CITY OF PORTLAND, MAINE

PLANNING BOARD

December 2, 2013

Project Name: New Yard at Canal Landing, Phasing Amendment
Project ID: #2013-224
Address: 40 West Commercial Street
CBL: 59-A-1,2,3,4,5,6,7,8,9,10,11,12
Applicant: New yard, LLC
Planner: Bill Needelman, Senior Planner

PROJECT: CANAL LANDING (PHASE 1A)  
 TITLE: FIRE PROTECTION PLAN PHASE 1A ONLY  
 CLIENT: NEW YARD LLC  
 58 FORE STREET  
 PORTLAND, ME 04101

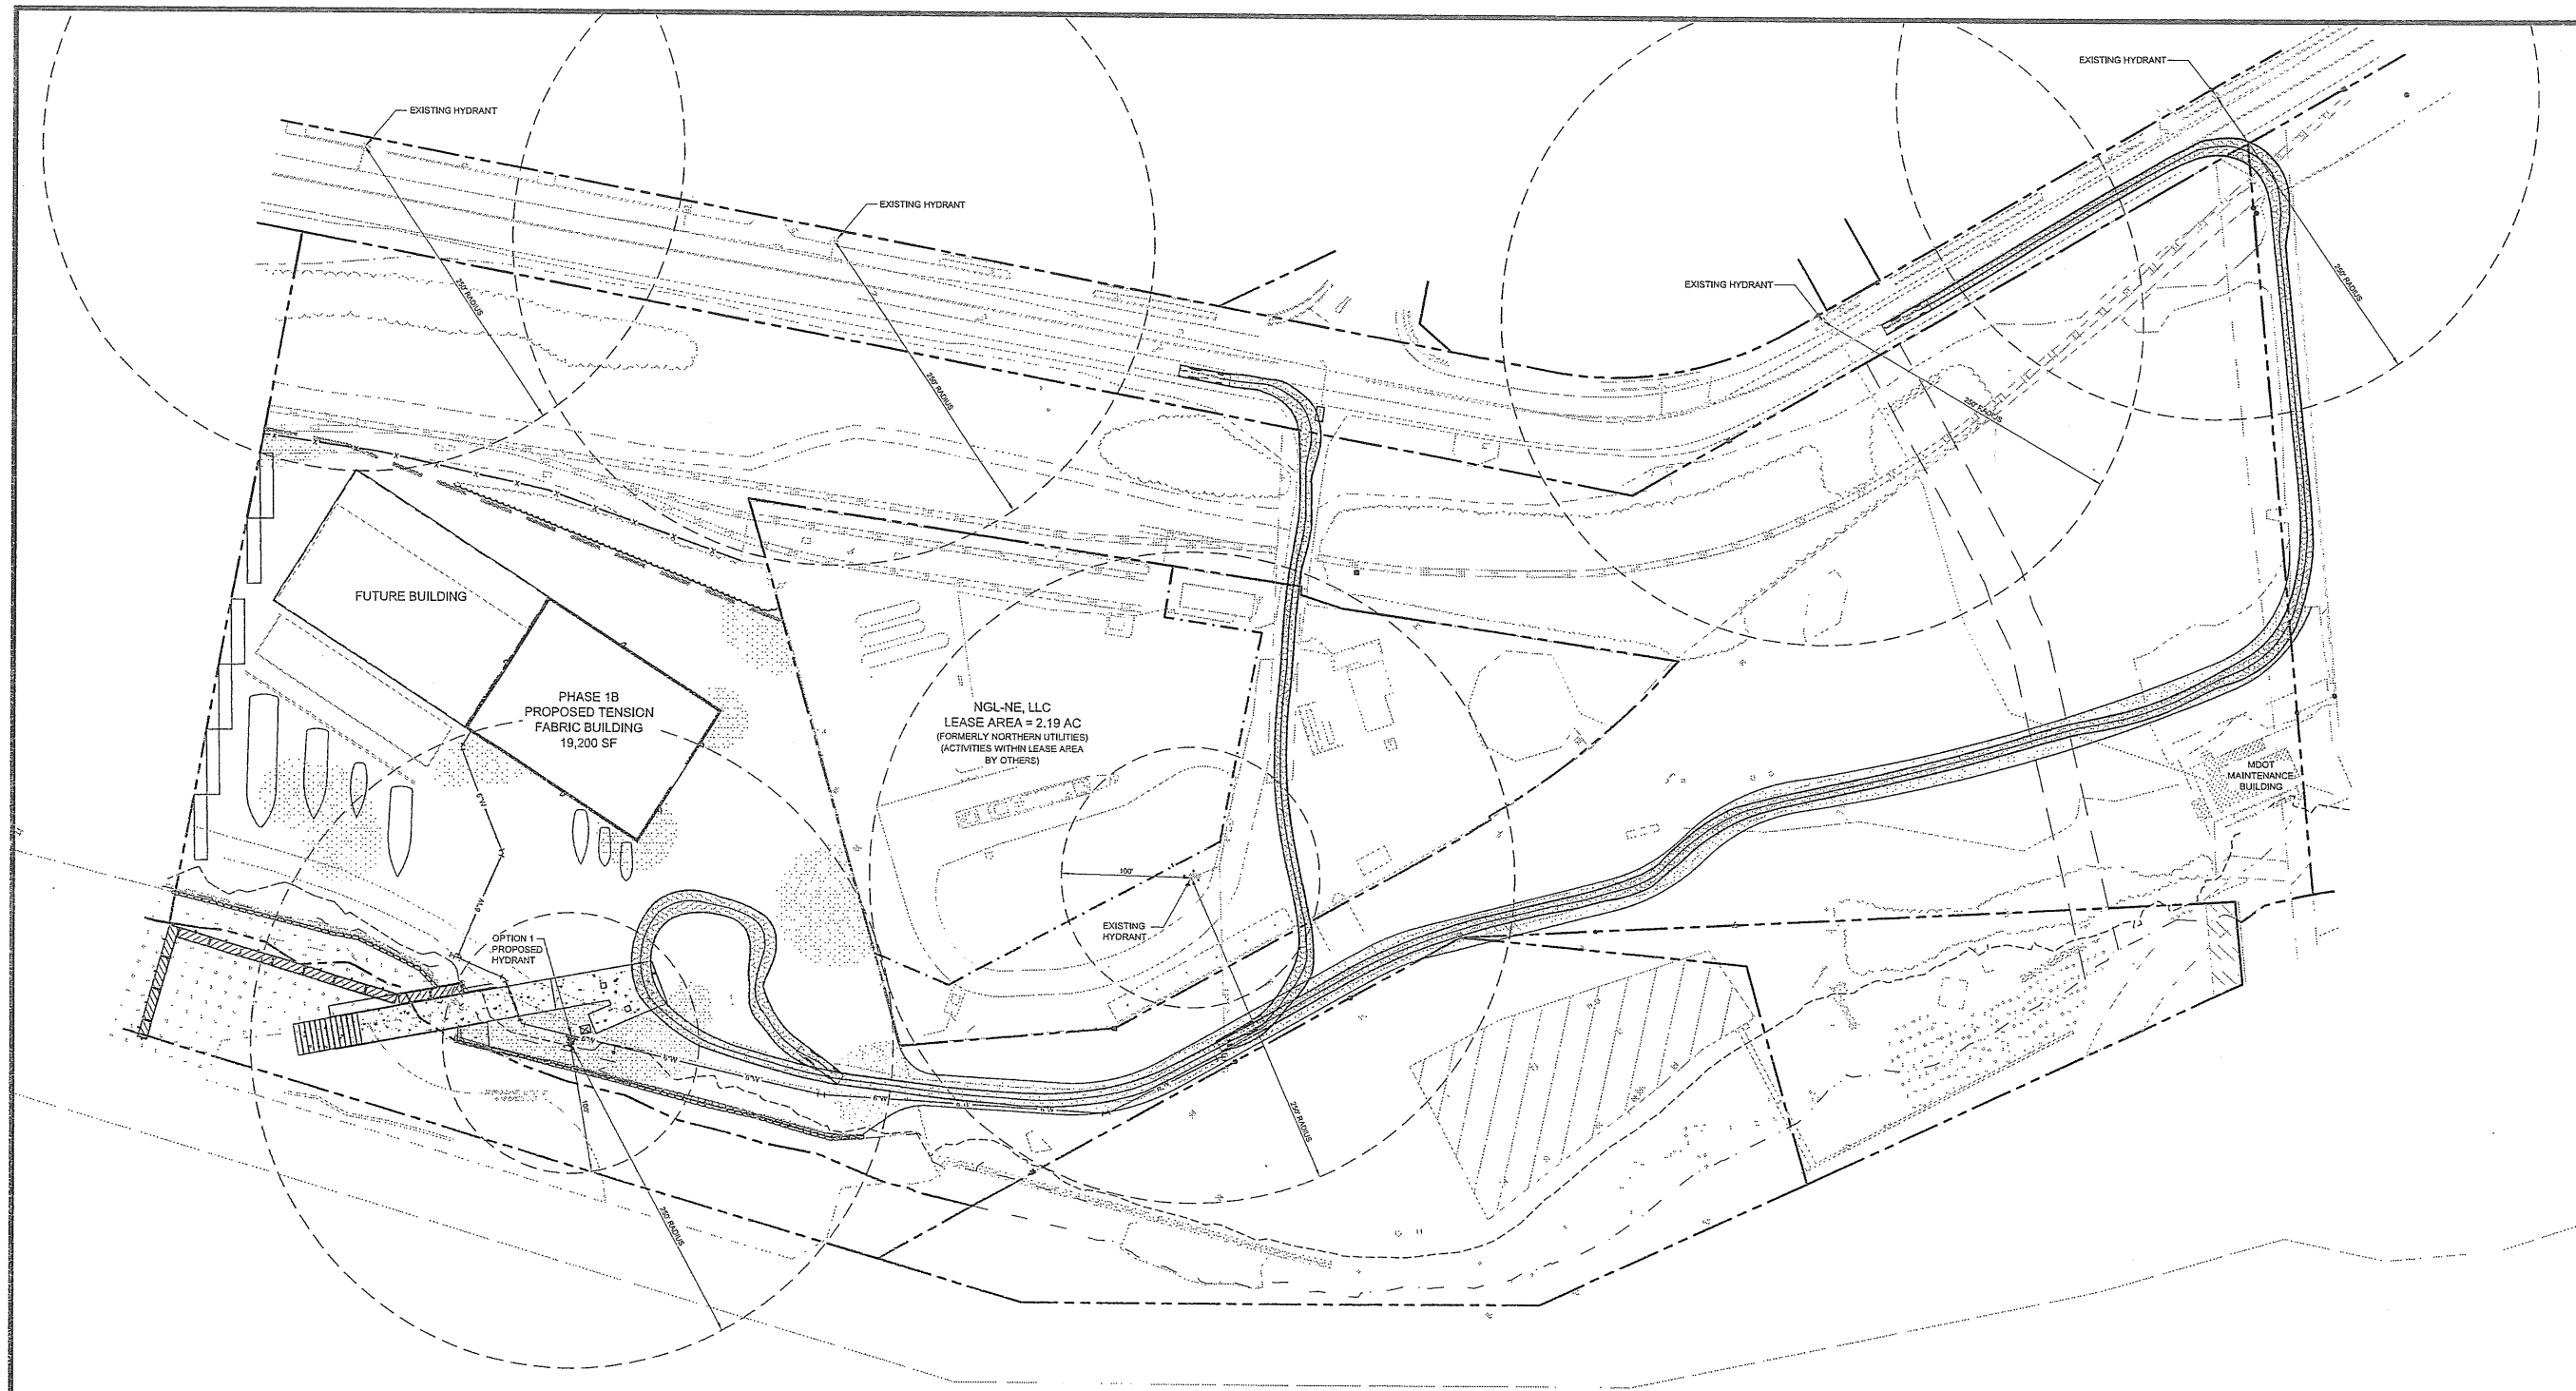
- ii. *Fire Safety and Emergency Access:* *Prior to issuance of a building permit, the revised fire access and circulation plan, as may be amended, shall receive review and approval from City Fire Safety review staff.*
